SHANNON DUSKIN
267 CAPITAL HILL RD
LILLINGTON NC

This review is approved
only with the notes
provided

WEST ELEVATION

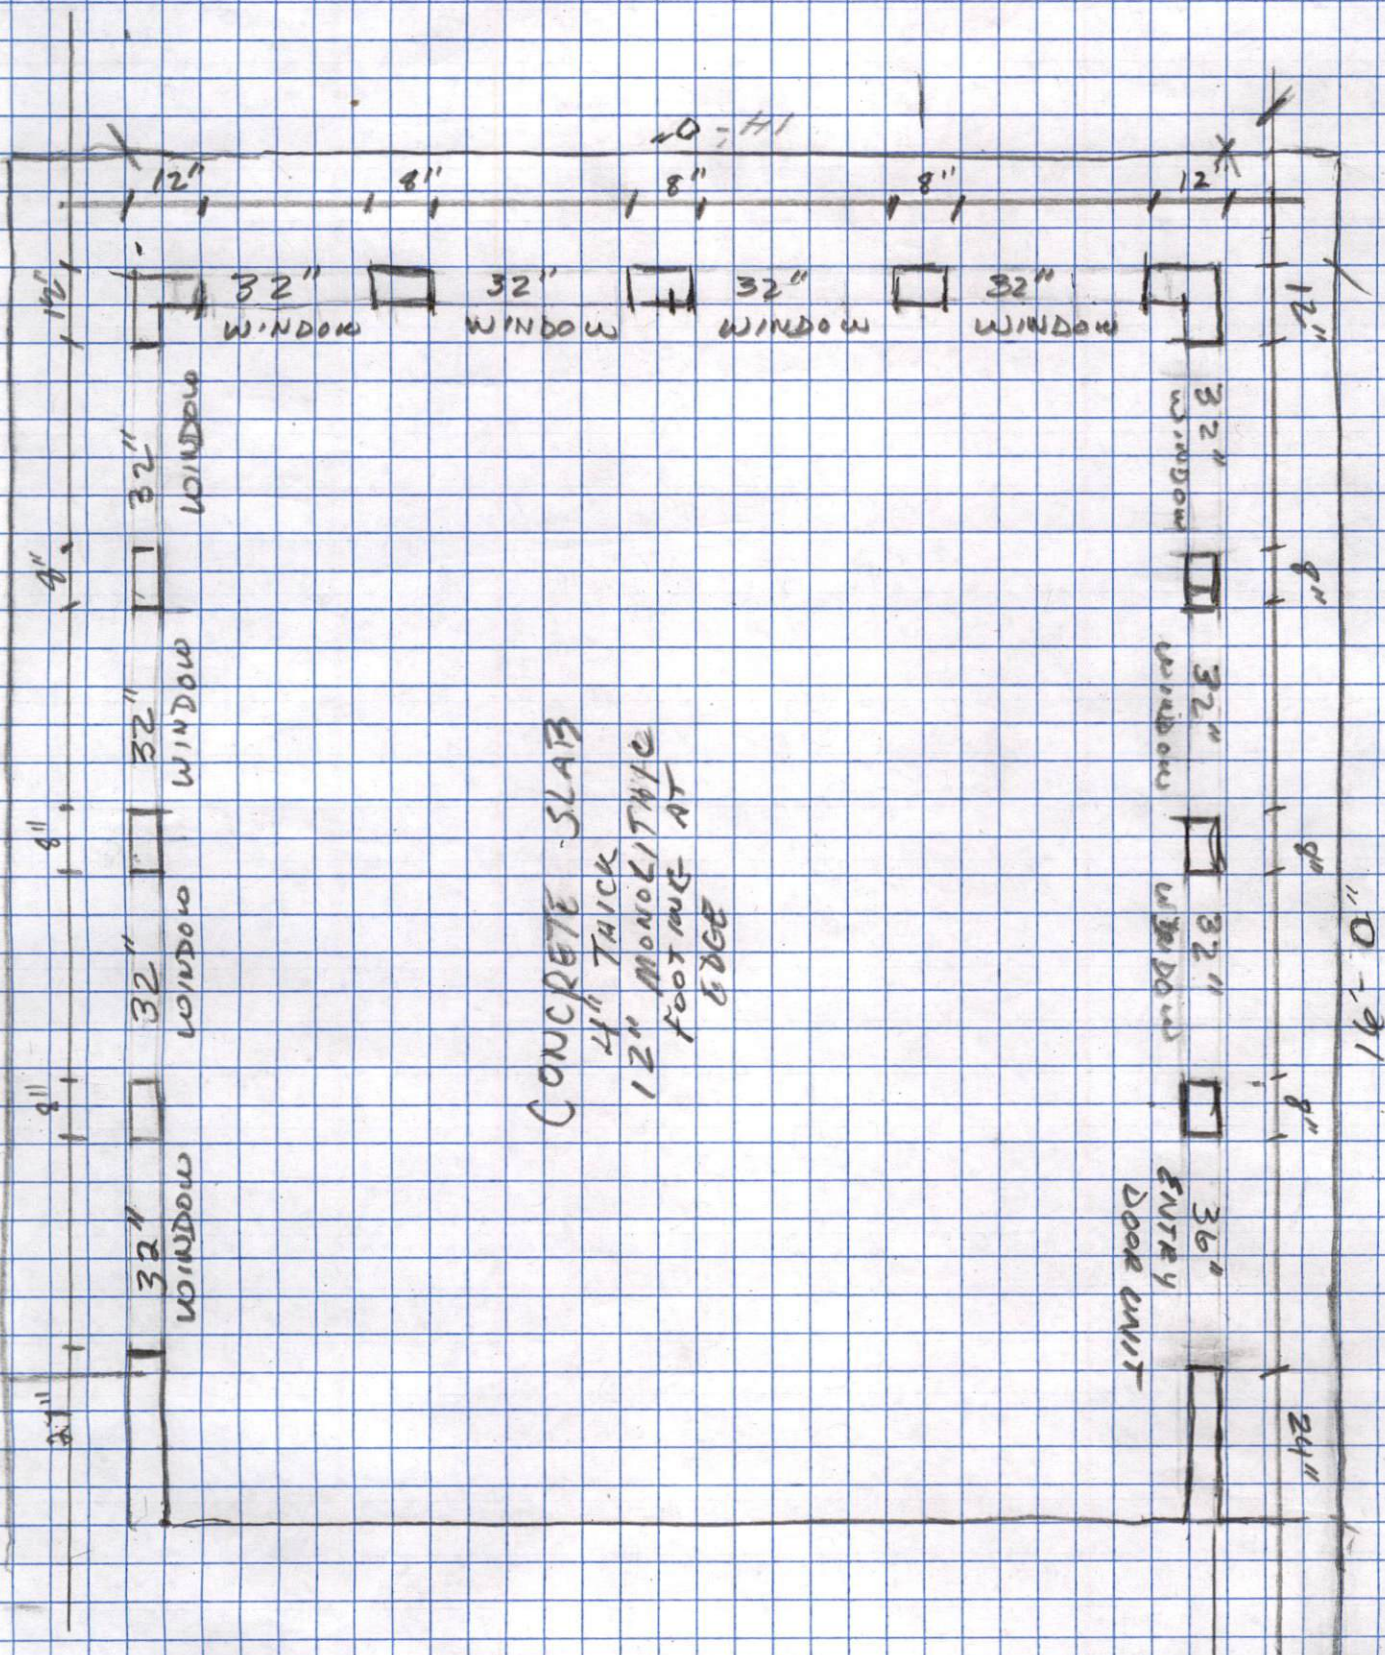
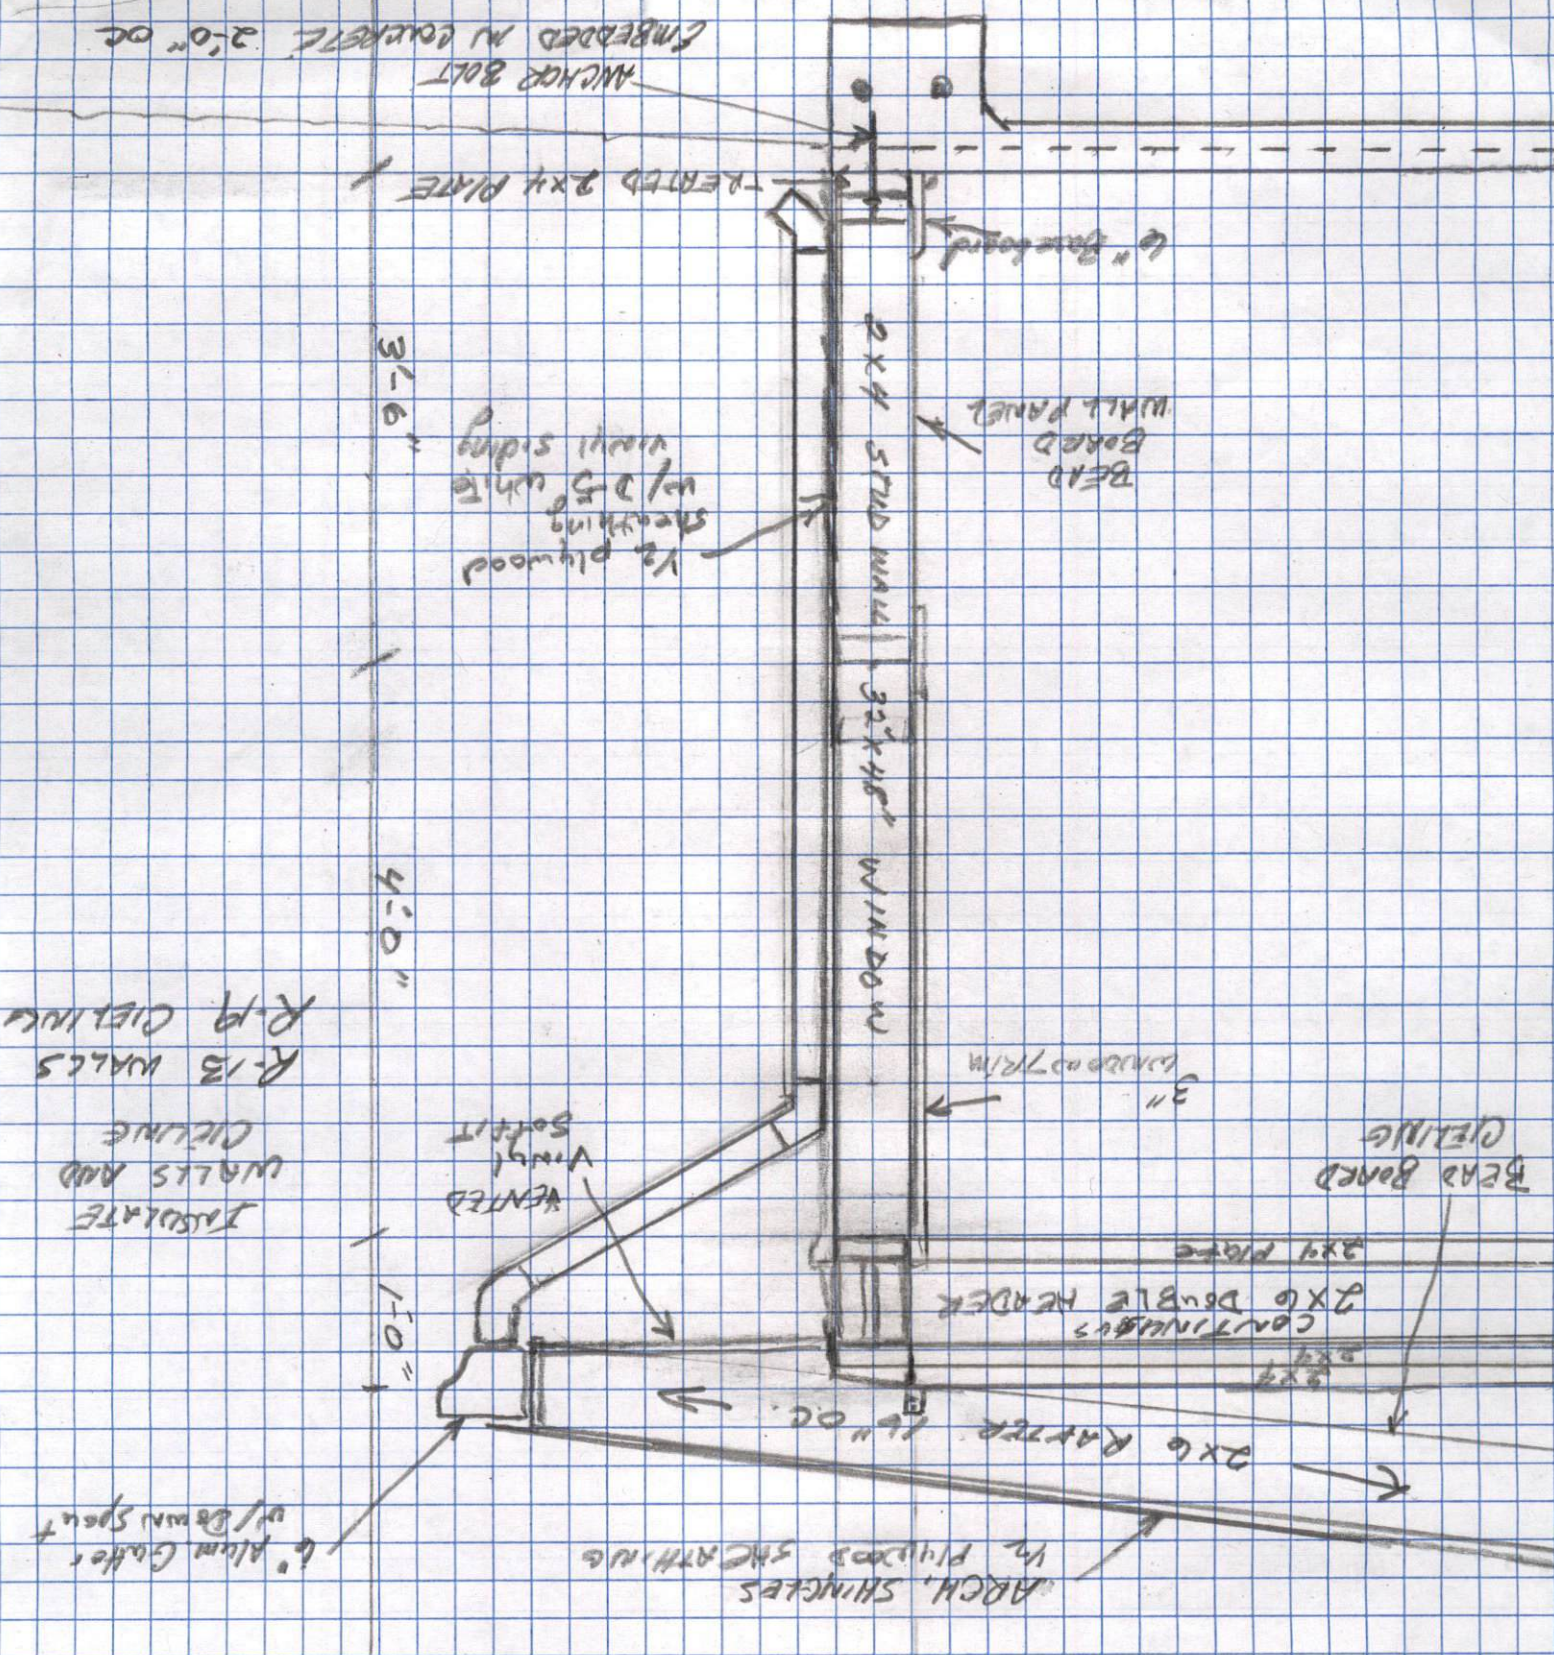
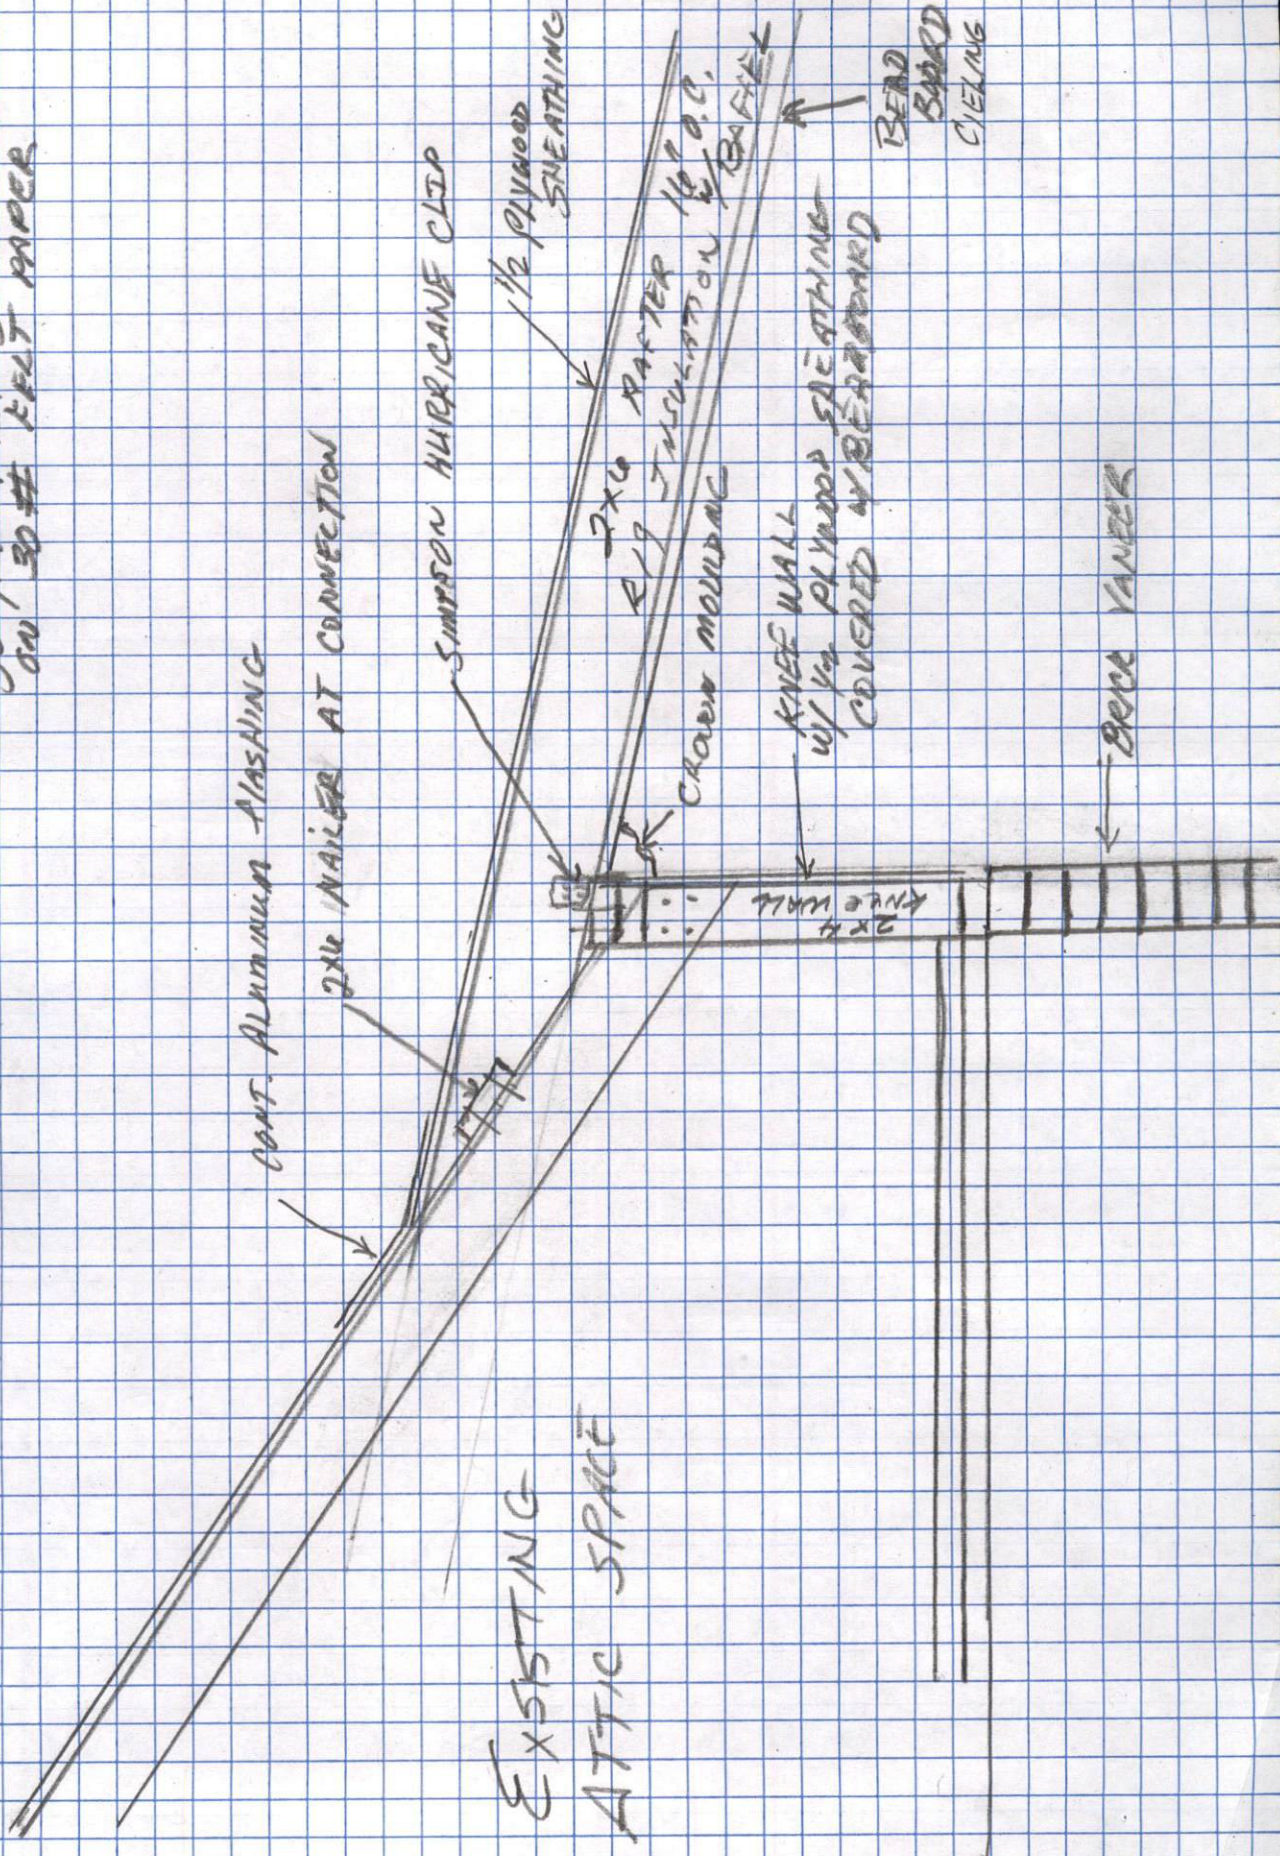
To use the the insulation values provided, the sunroom shall remain thermally isolated from the remainder of the structure. Heating and cooling shall not be via existing system in house

Roof slope shall be 2:12 minimum.
2:12 to 4:12 shall have minimum
30# felt double lapped
underlayment

Knee wall shall not be supported on
brick veneer. Must be supported by
structural framing/ exterior wall
